FG/168/18/PL

The application is for a new dwelling in the grounds of a detached property which fronts on to Sea Lane. The application site is located in the immediate setting of the Ferring Conservation Area.

Drawing Title
Proposed Plan and Elevations

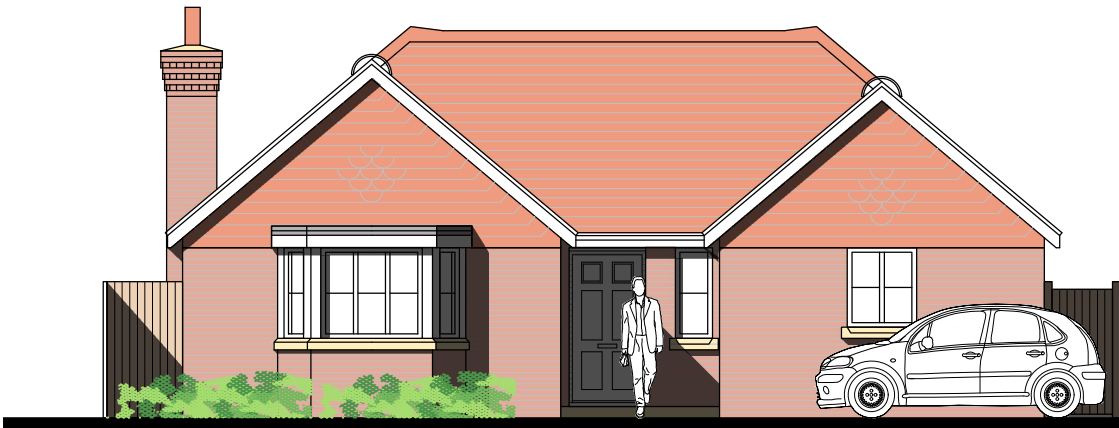
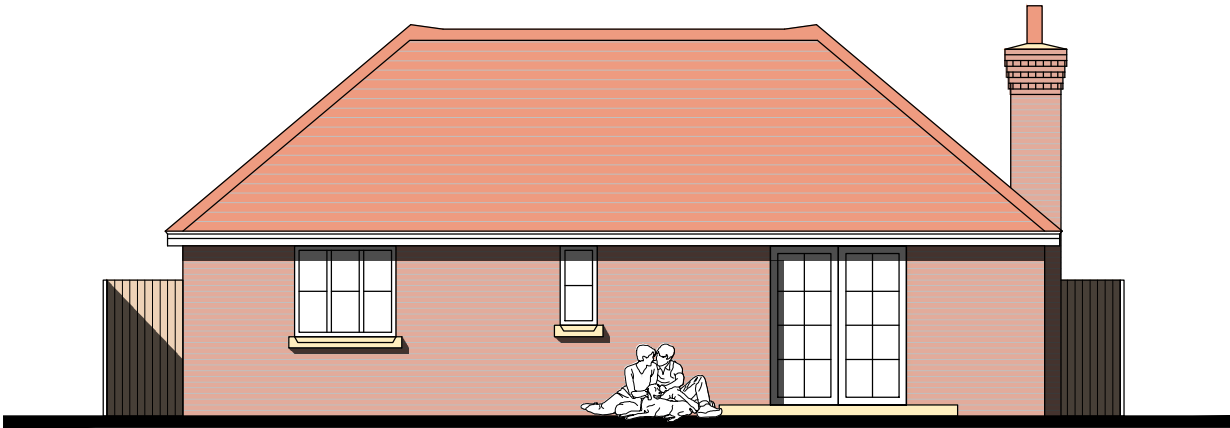
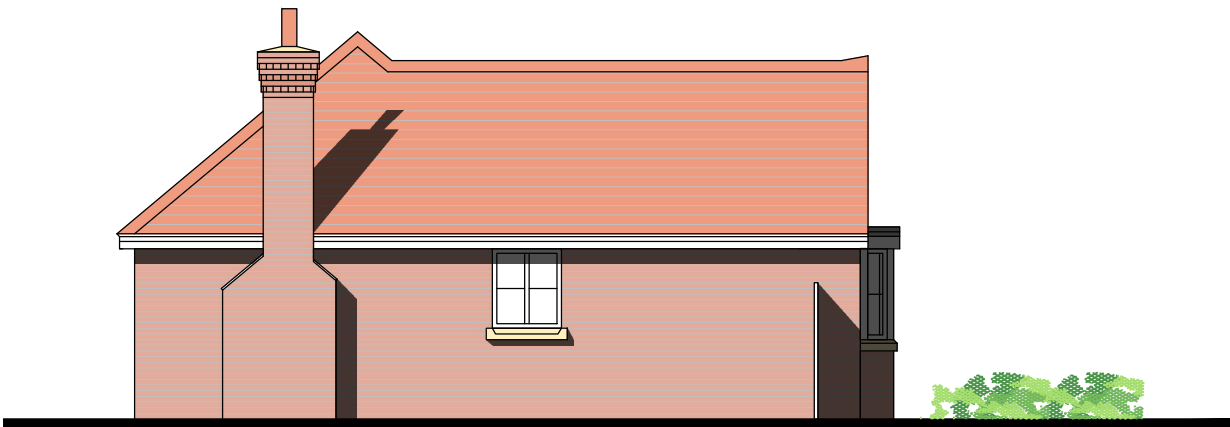
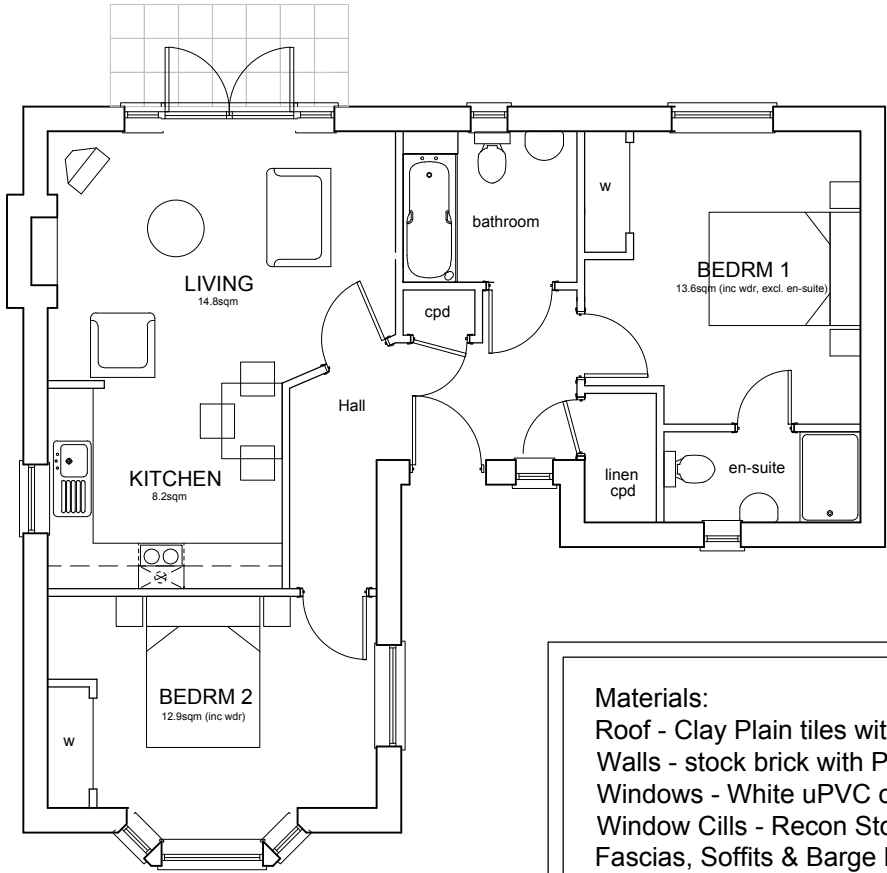
The proposed development occupies a fair amount of the existing residential curtilage, and may be considered to be over development. Such a proposal results in limited amenity space for both the existing and new properties.

Development to the immediate west and south-west of the application site (within the Conservation Area) are modern in nature and essentially screen the site from within the conservation area. As a consequence, it is considered that the proposed bungalow will have a neutral impact upon the character or appearance of the conservation area.

However, if you are minded to approve the application you may wish to condition details of the materials to be used.
